**RE: Main Event, Albuquerque Carpenters Training Center, Pan American Freeway  
and Vassar Drive  
Grading Plan and Drainage Plan  
Engineer's Stamp Date 5-14-2015 (File: G16-D149)**

May 8, 2015

**RE: MAIN EVENT,  
PAN AMERICAN FREEWAY AND VASSAR DRIVE  
GRADING PLAN AND DRAINAGE PLAN  
ENGINEER'S STAMP DATE 3-27-2015 (FILE:G-D149)**

C6

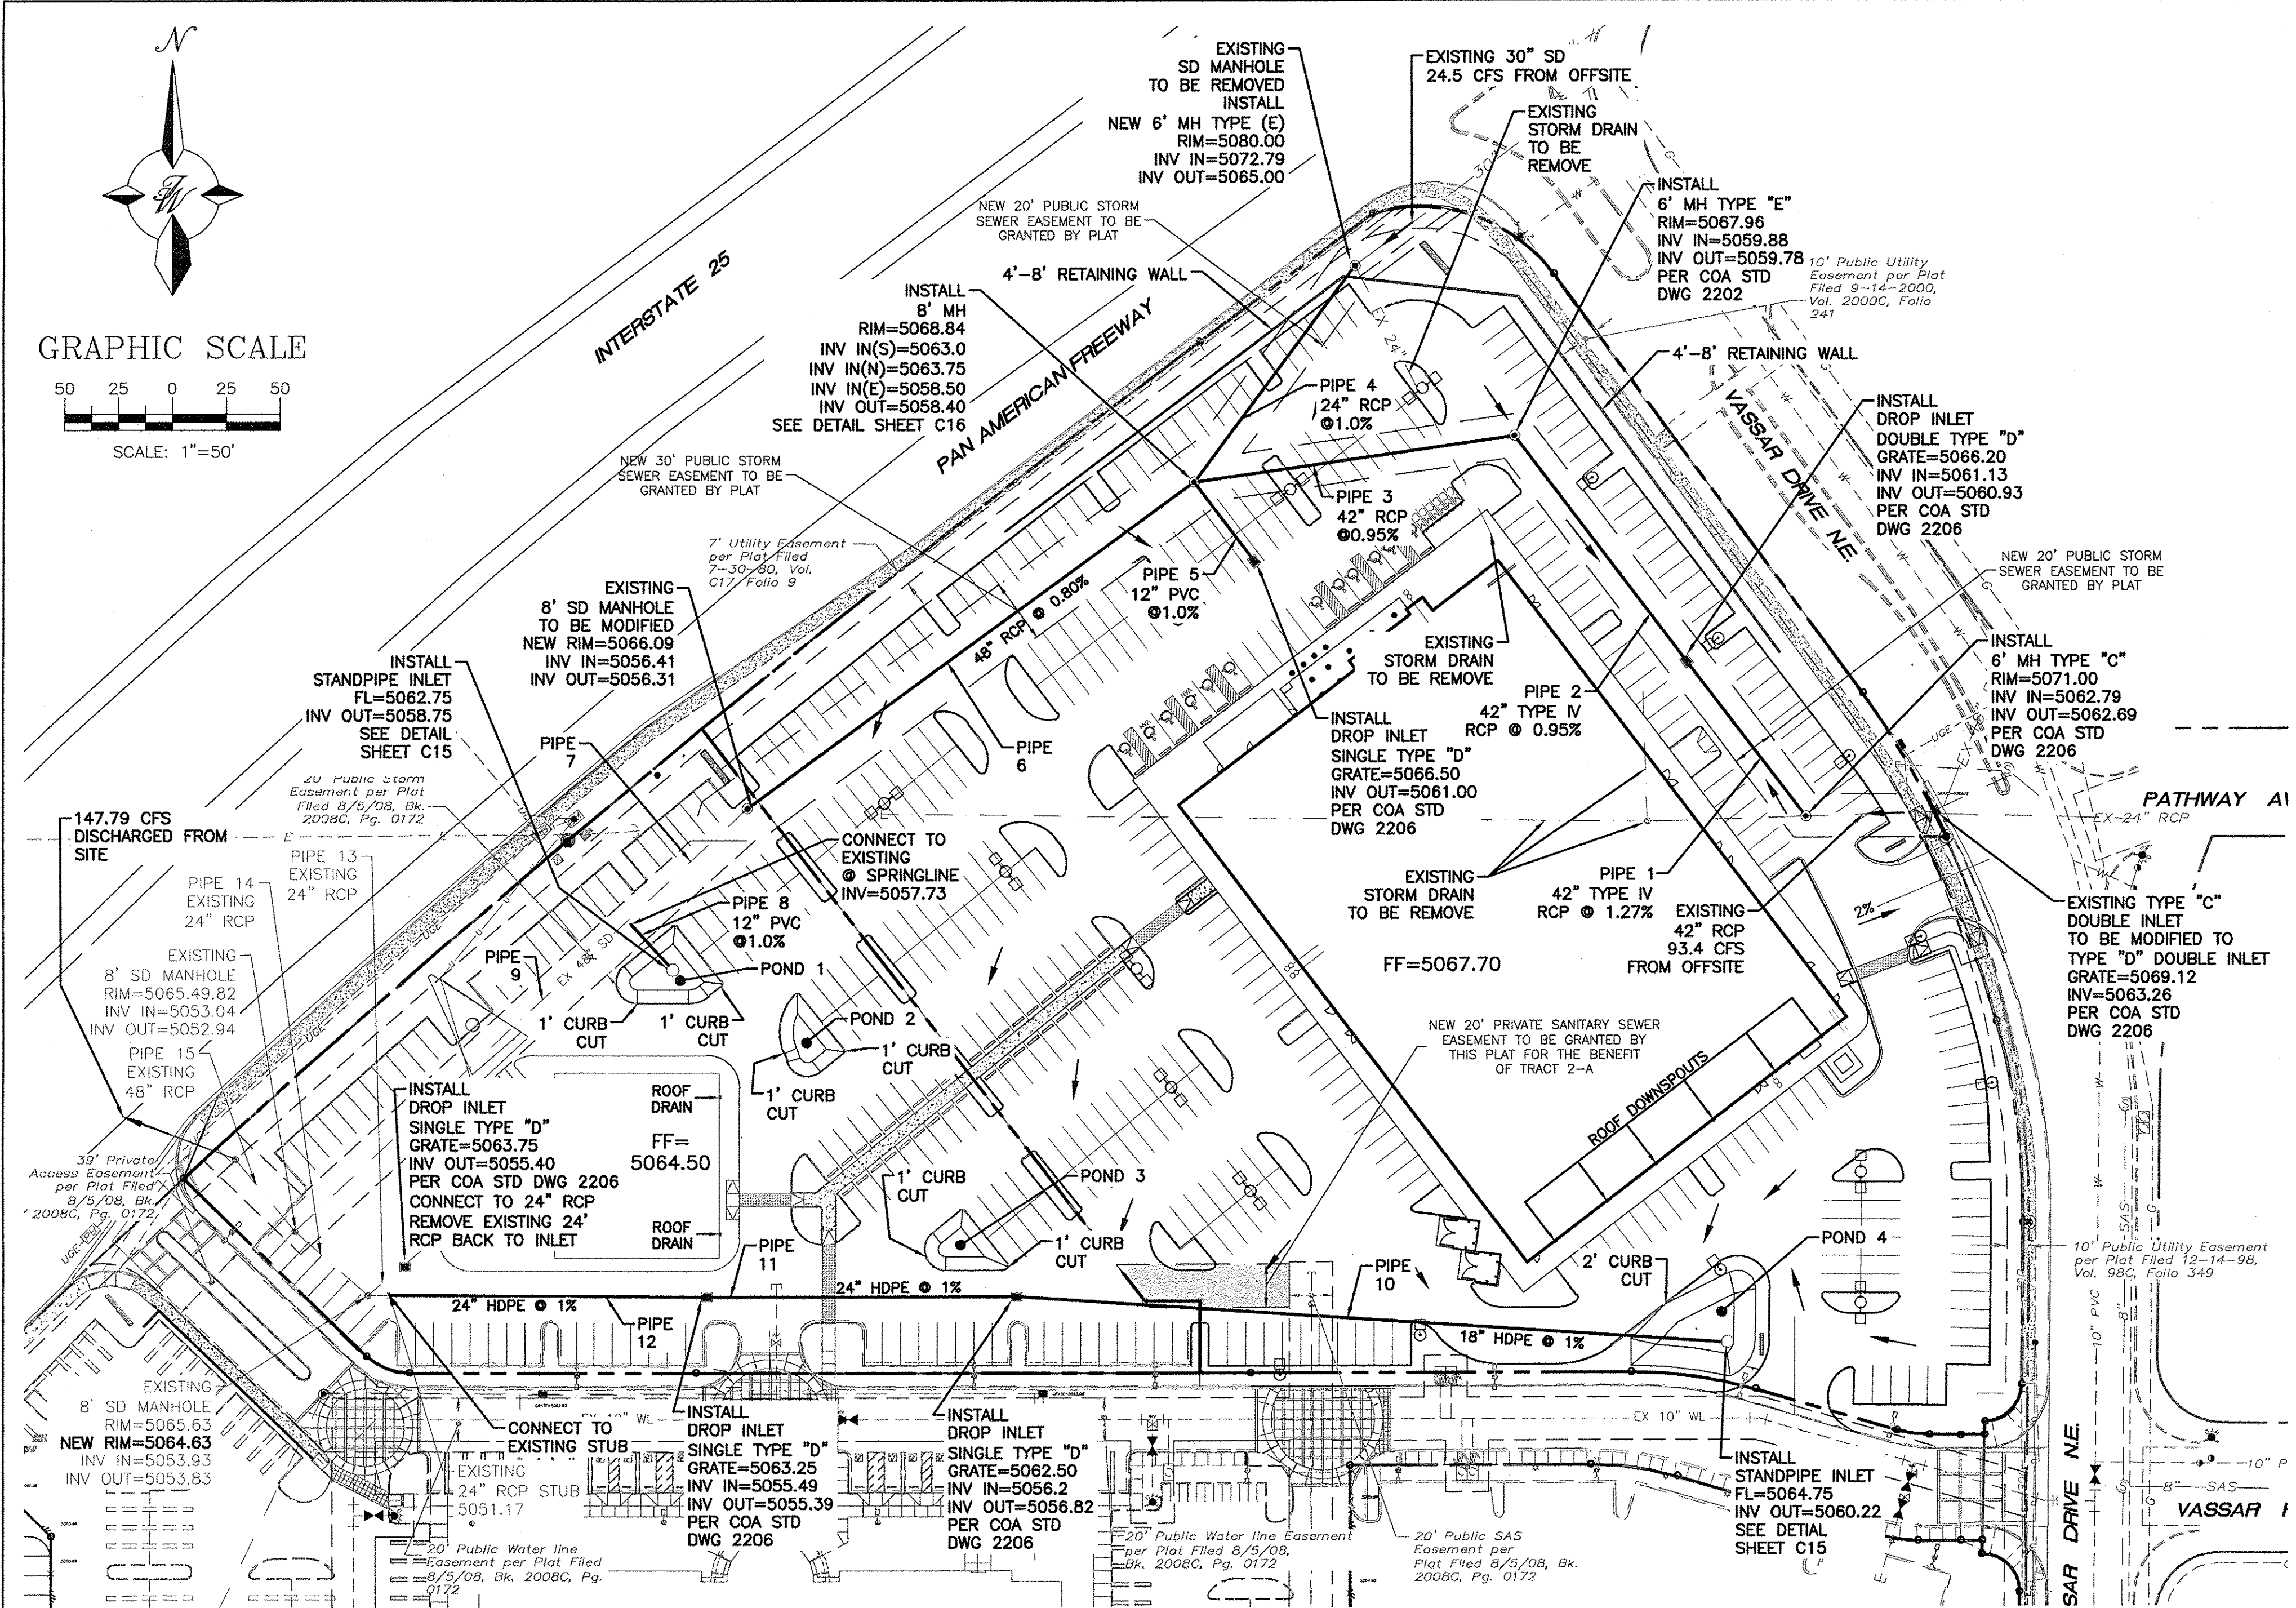
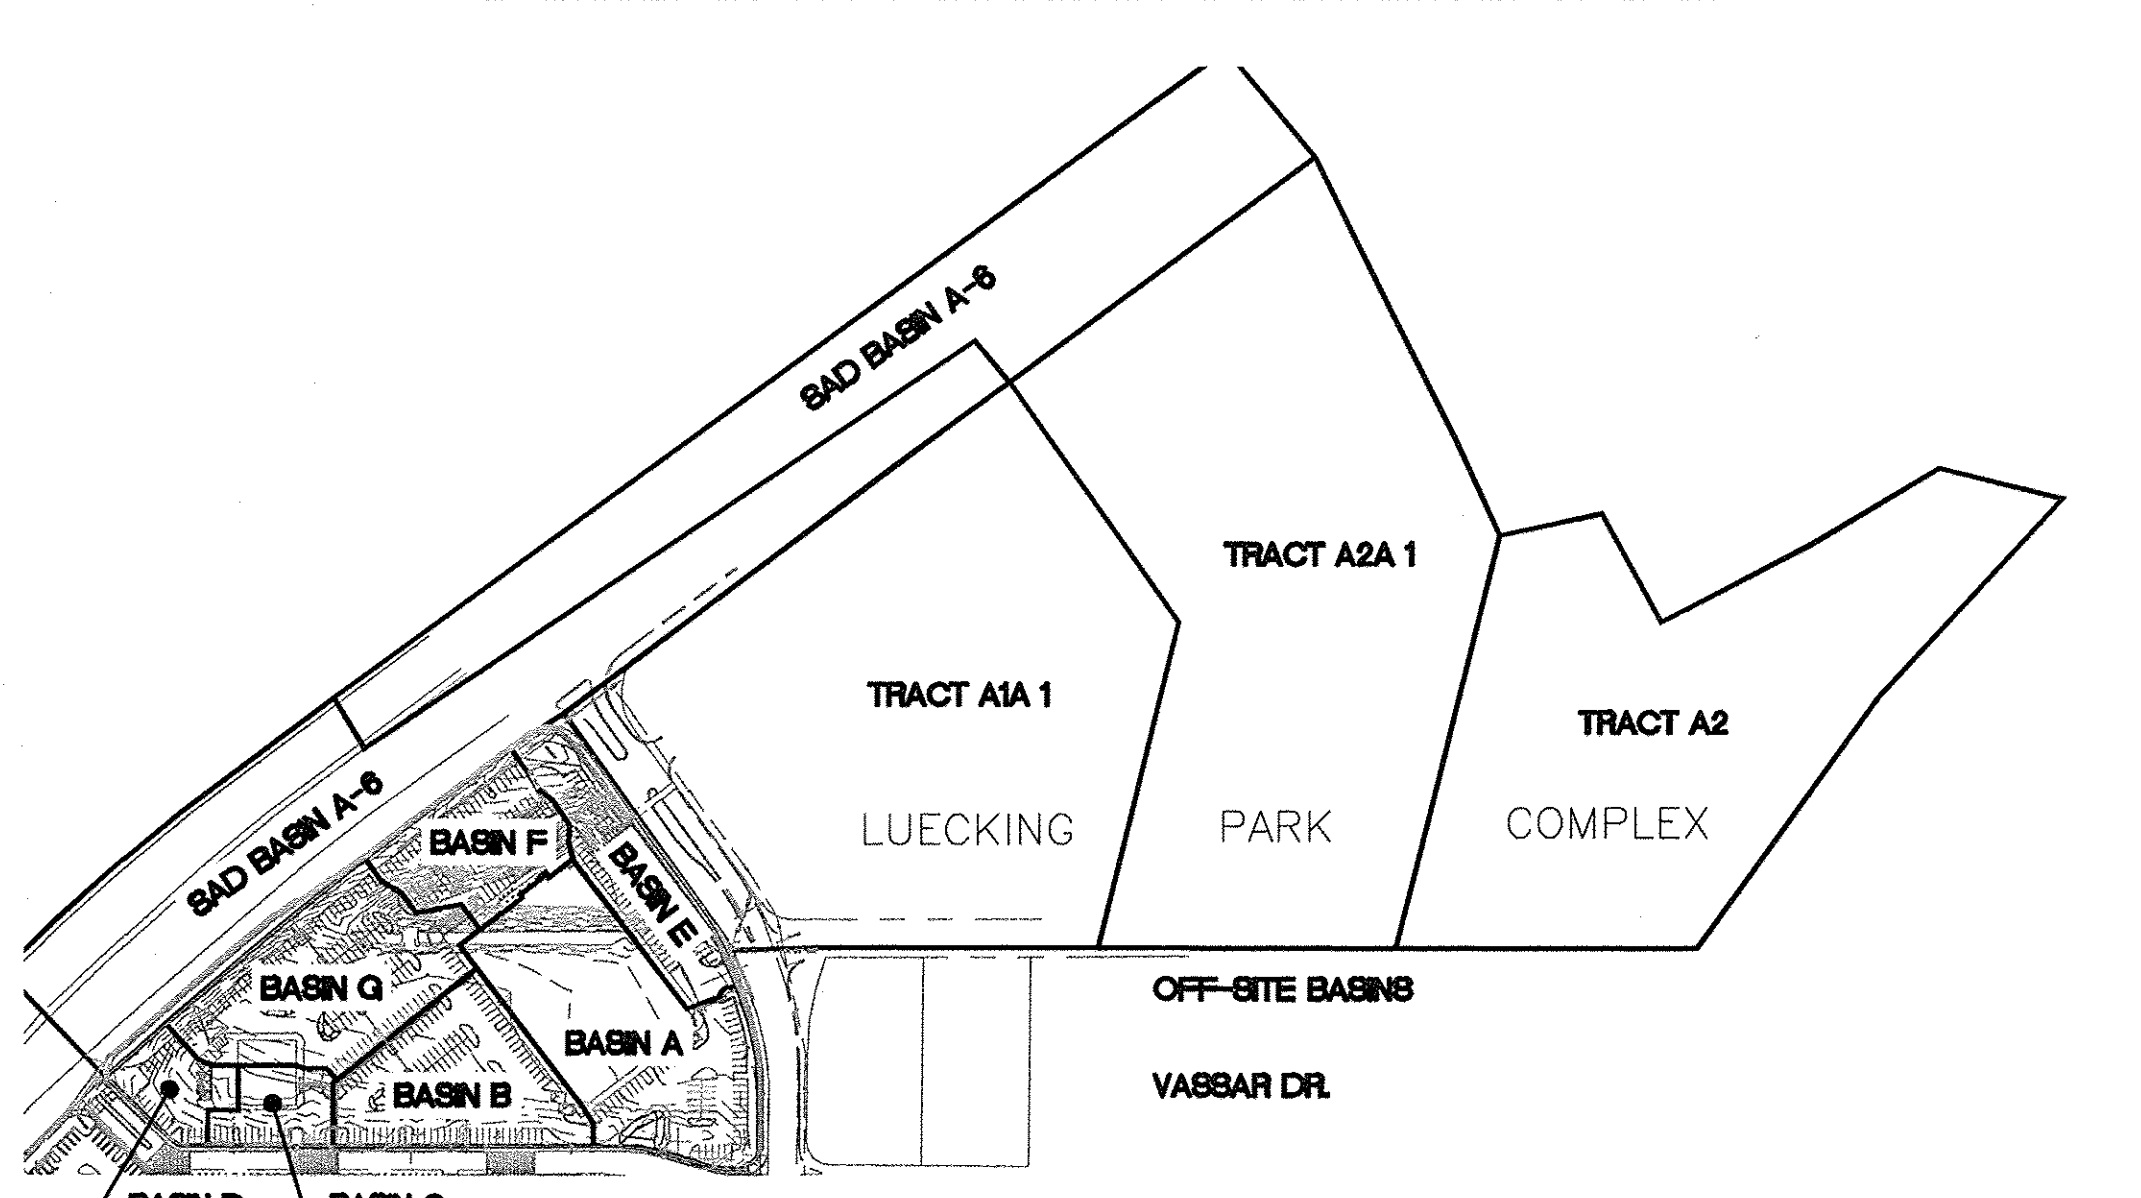
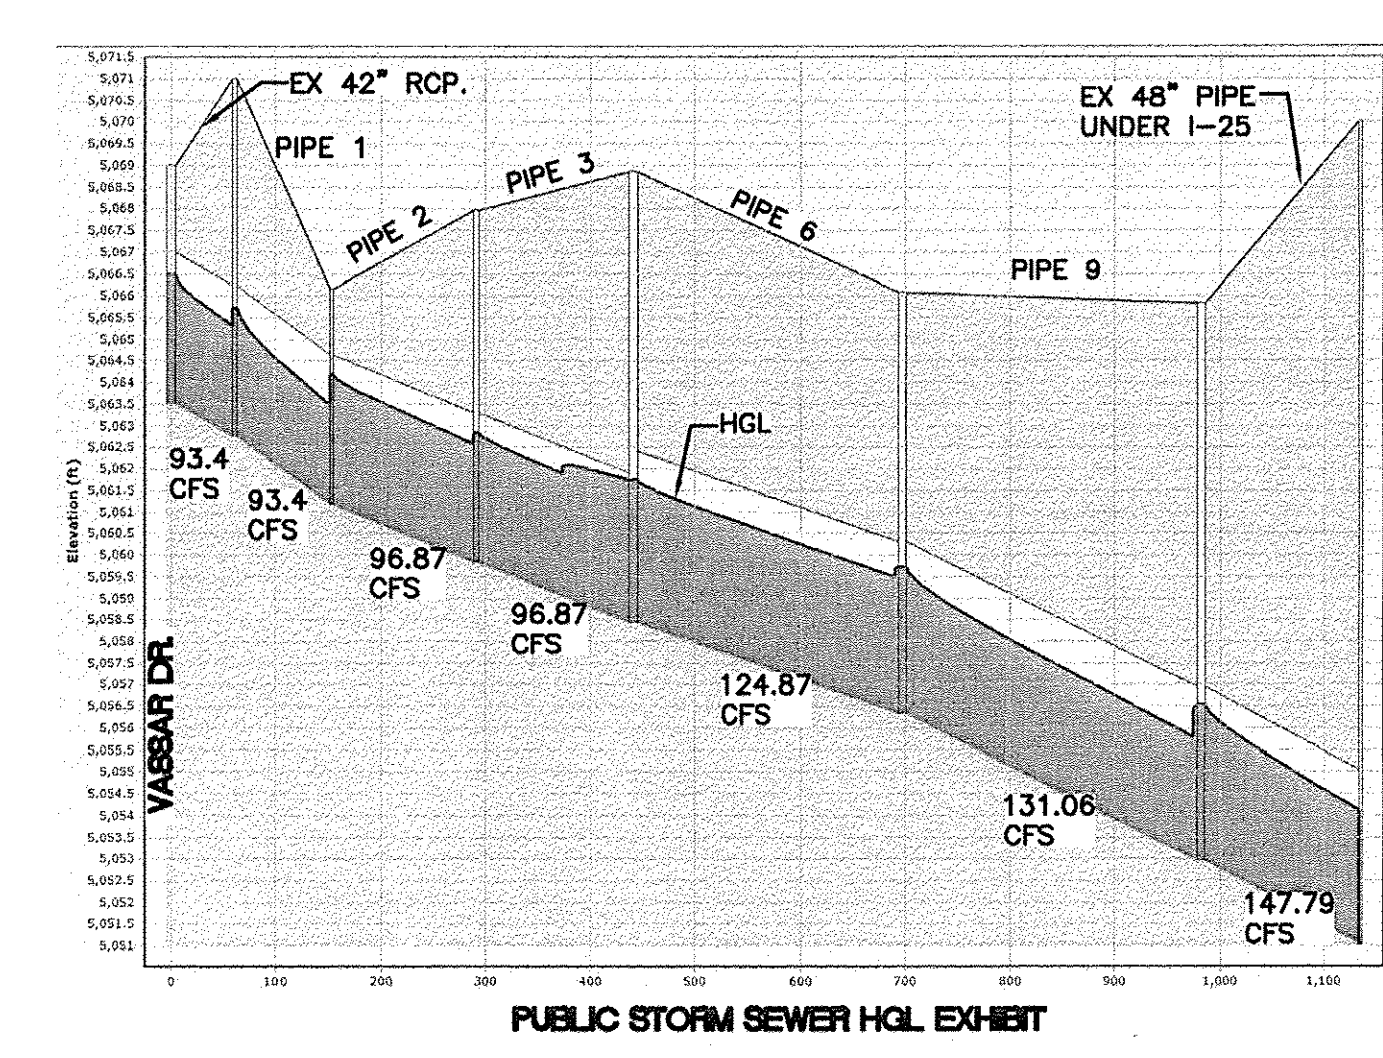
1. Show computations for the first flush on this site, and explain how it will manage. The volume required to be retained is 0.34 inches times the impervious area. **The first flush calculations are now shown on Sheet C6.**

4. Include inlet capacity calculations within next submittal and inlet details. Show grate elevations for these inlets on the 'Grading Plan' which correspond to the 'Drainage Plan'.

There are a couple of discrepancies including and difference of about one foot between grate elevations and grade elevations at the same spot including two grates along the northwest side of the site that show grate elevations of 5063.75 and 5065.50. **These typographic errors were corrected and the grate elevations are labeled on the Grading Plan. The drop inlet calculations can now be found on Sheet C6.**
